Comment for planning application 23/00750/TEL56

Application Number	23/00750/TEL56
Location	Street Record Station Road Kirtlington
Proposal	Proposed telecommunications installation: Proposed 15.0m Phase 9 slimline Monopole and associated ancillary works
Case Officer	
Organisation Name	elizabeth summons
Address	Hillcrest, Station Road, Kirtlington, Kidlington, OX5 3HE
Type of Comment	Comment
Type	neighbour

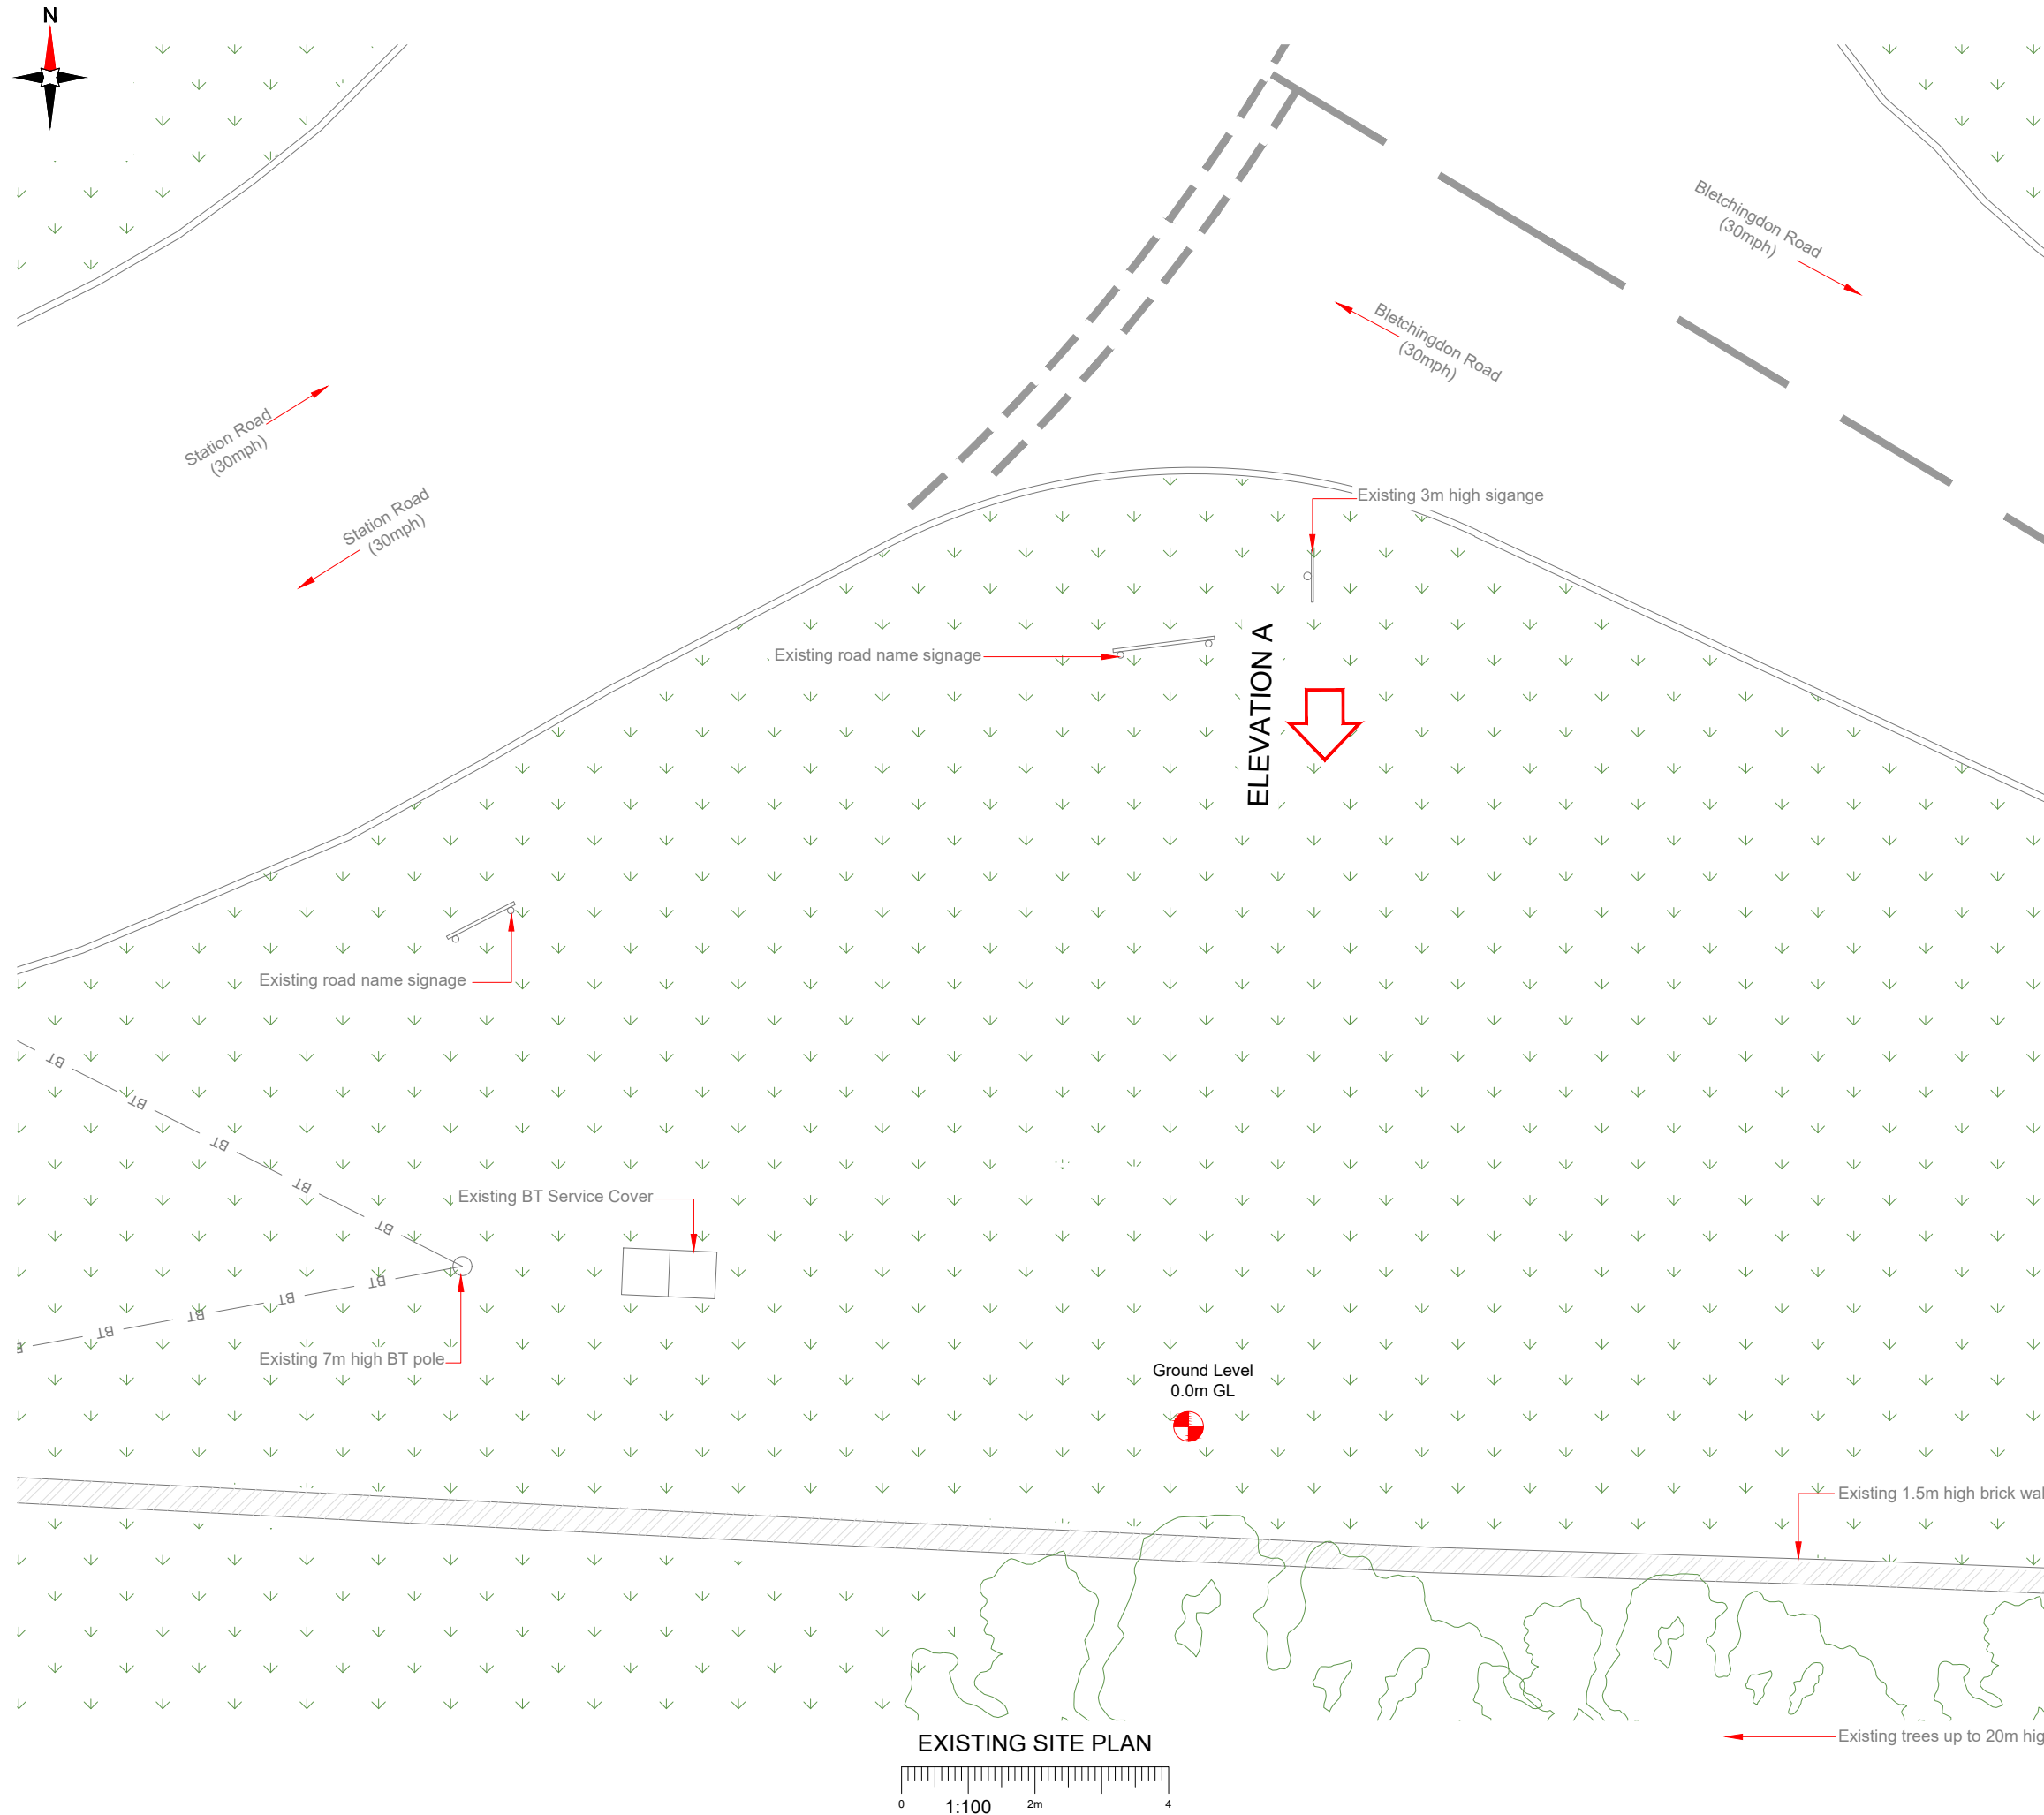
10. Site location plans:

Each photograph is taken to show zero residential properties, and each diagram shows a tall tree. Firstly, the photographs are completely misleading being taken from these angles. Please see attached photographs to see residential properties within meters of site. Secondly, to be reliant on that tree standing forever is irresponsible and unrealistic. These are large old trees which will come to the end of their lives. In addition, there is no photography to show the actual look of the mast, meaning the application does not show the true impact of how invasive this structure will be to the whole village.

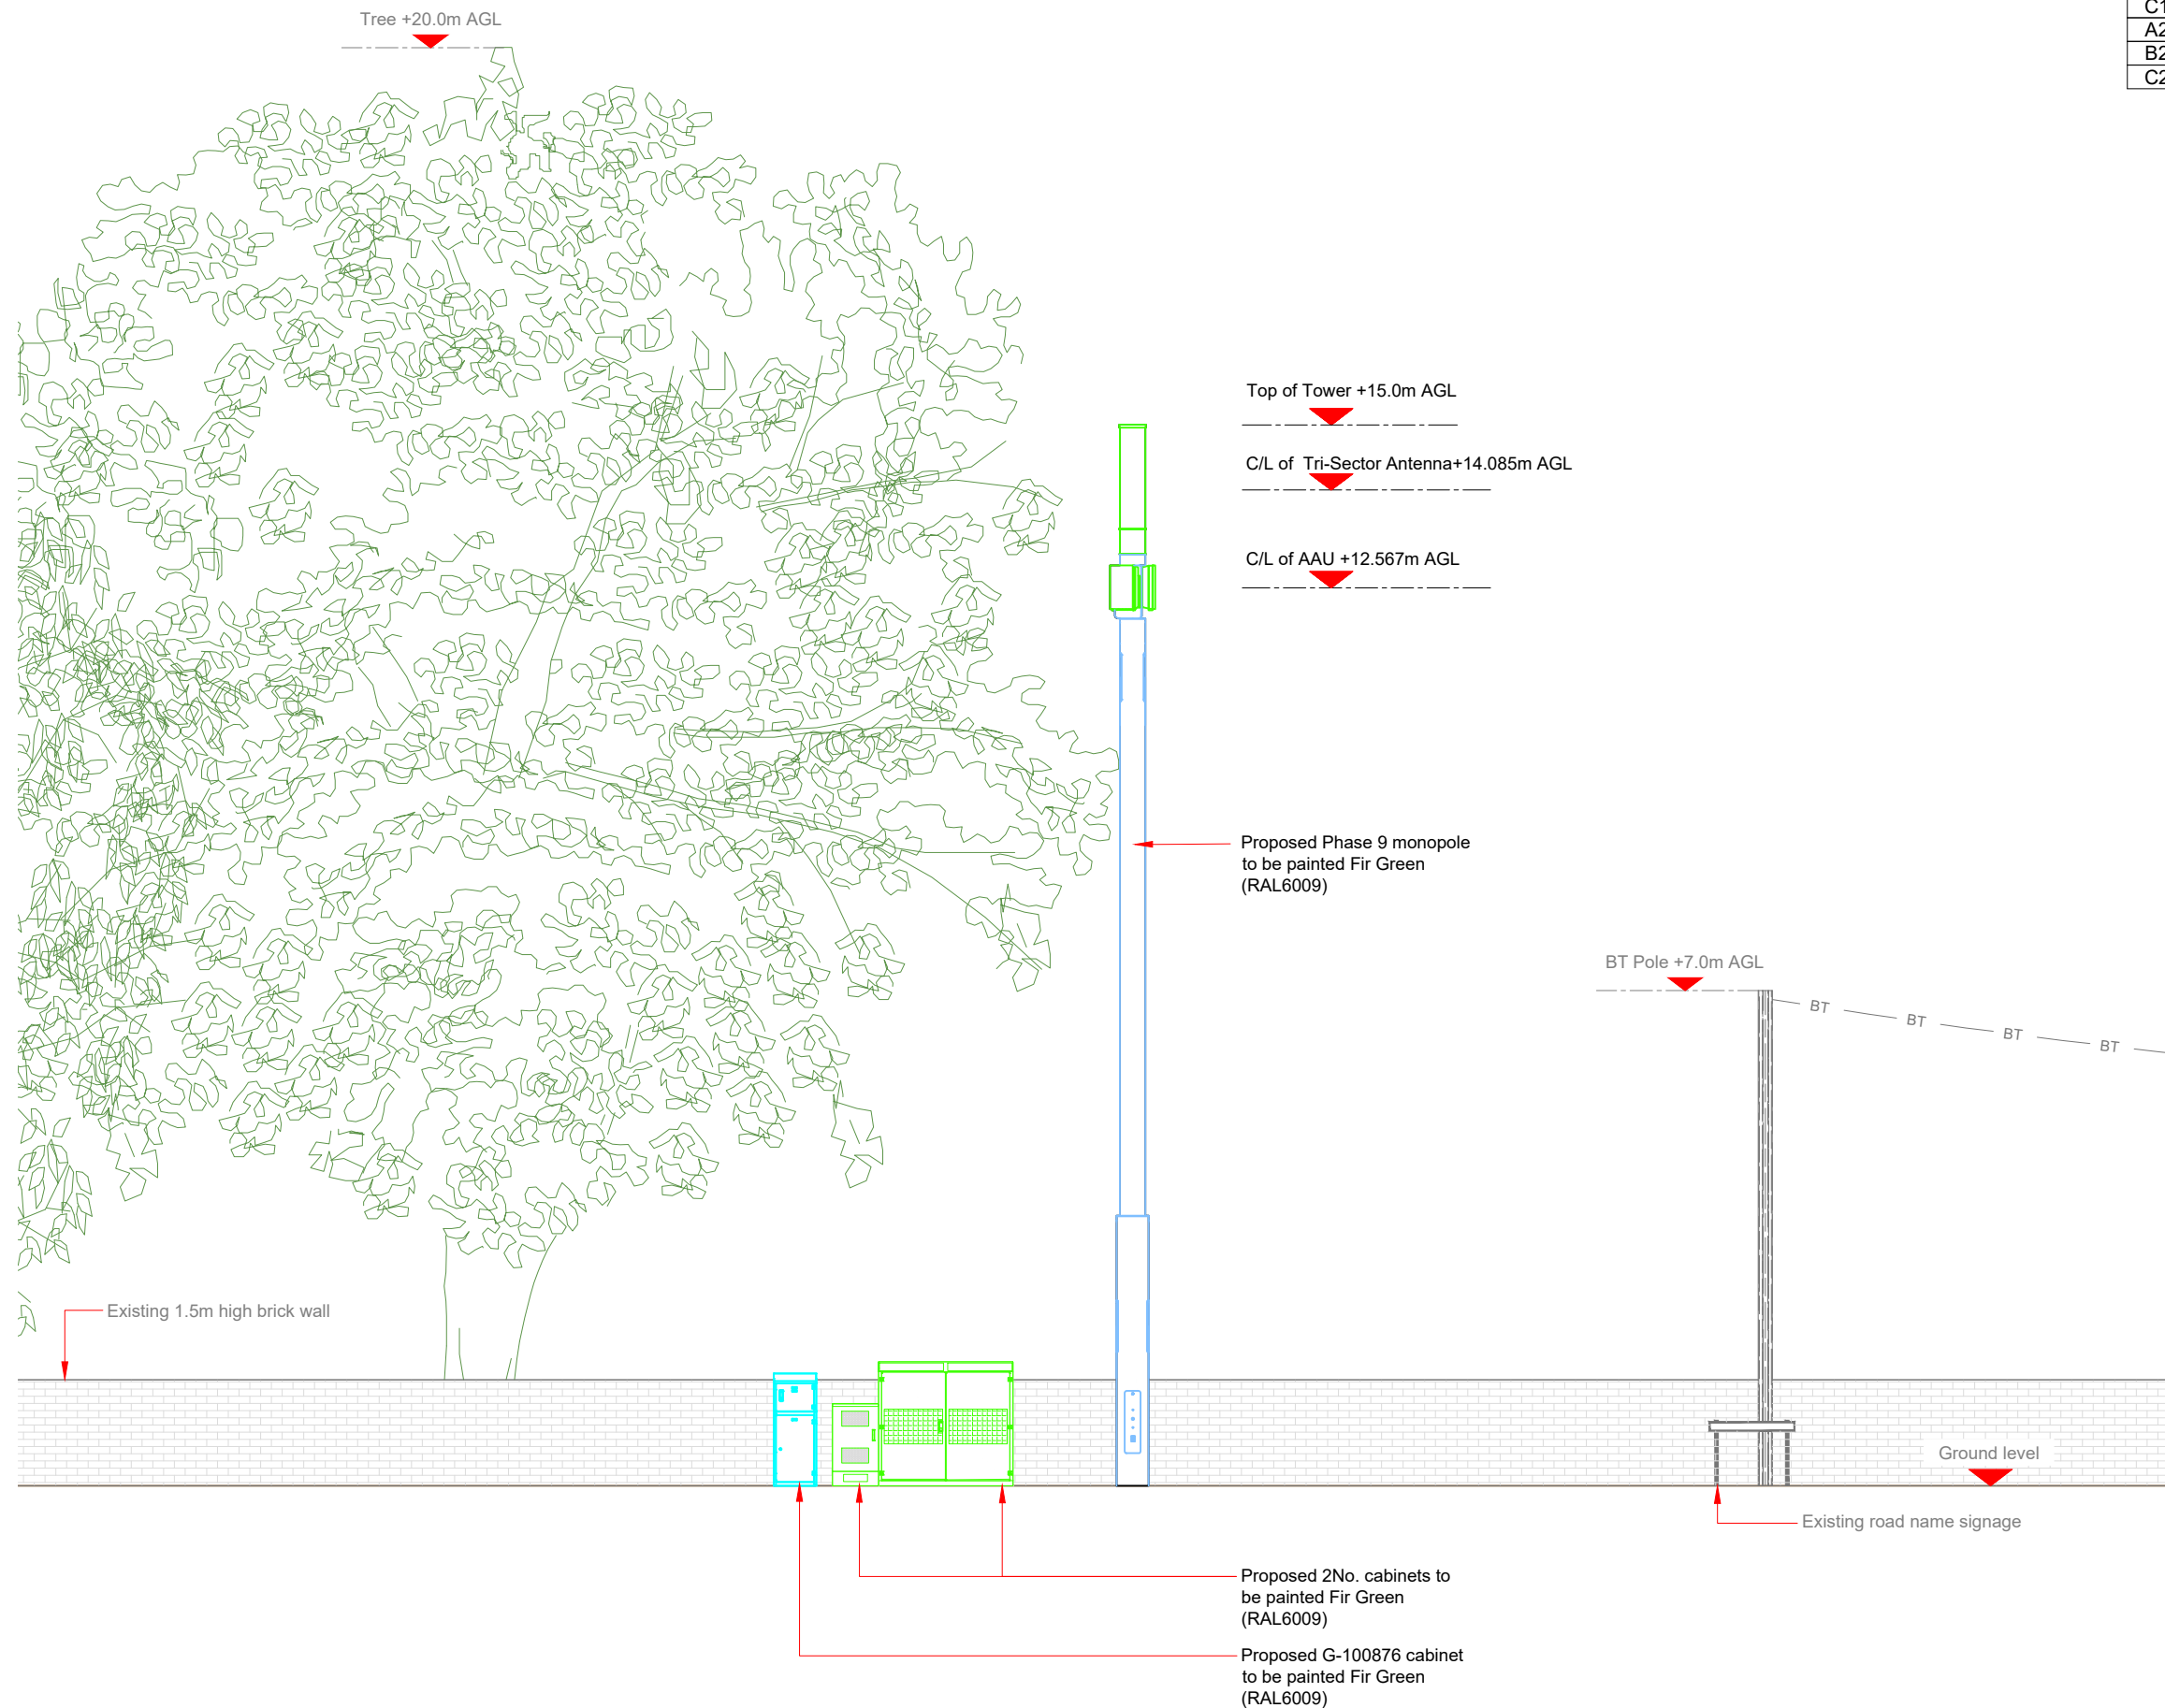
Overall I am astounded at the misleading nature of this planning application, in its plan drawings (of existing and proposed) including lack of details both in what the mast will look like bar a misleading drawing against a tree (which is only from one angle), and photography that shows very little of the actual area - including NONE of the surrounding houses who will be in direct line of the mast. The very fact that once again next to no one knows about it or was contacted officially suggests the proposers are trying to get it through under radar again. It was only brought to my attention due to one resident being sent a letter. It is now on Kirtlington village facebook in the hope, that before the holidays start, people object in time.

Figure 5:

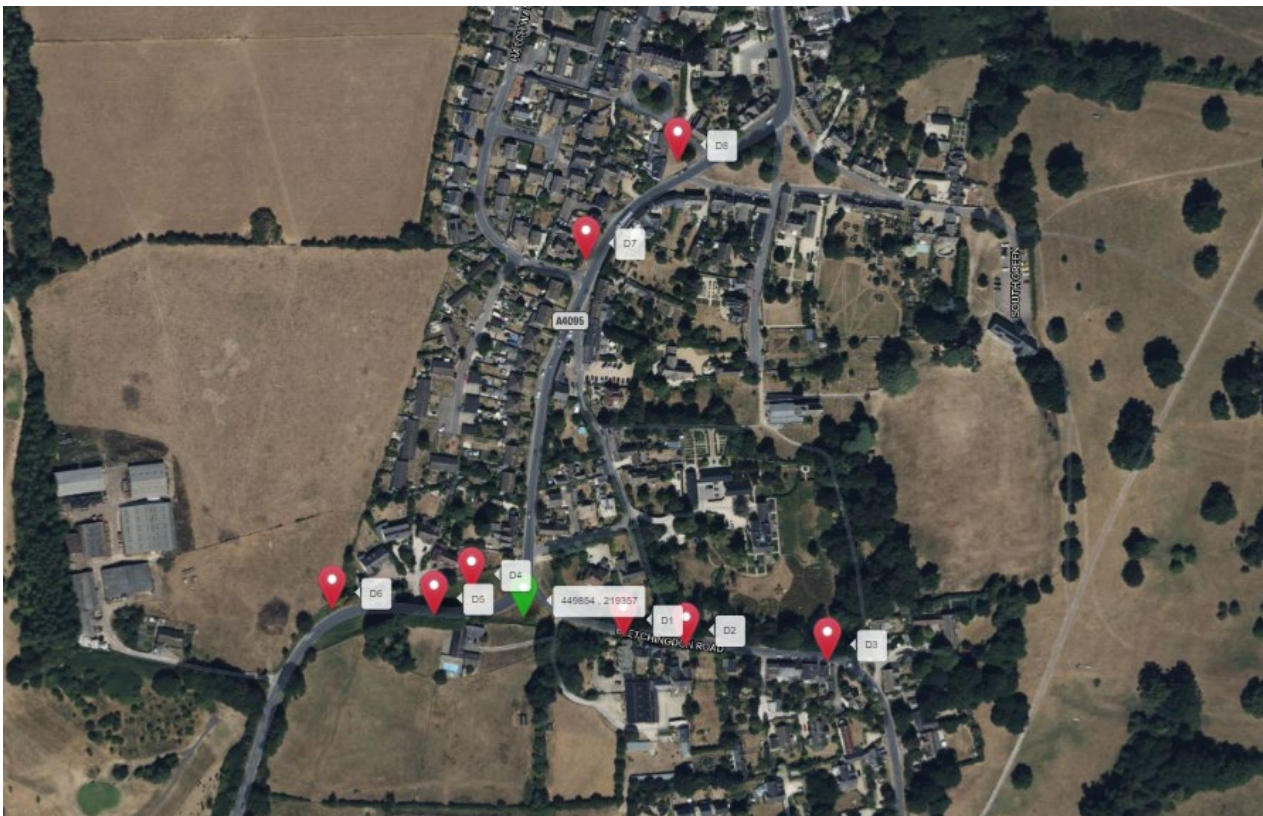
If you look at these and the map, they are all listed as : "highly visible from onlooking residential properties" INCLUDING the site they are proposing: "D4 - 449819 , 219374, Grass verge adjacent to Oxford Road discounted due to lack of screening. Site is highly visible from onlooking residential properties."

They have said themselves this site should be discounted! (see attached and photograph on application).
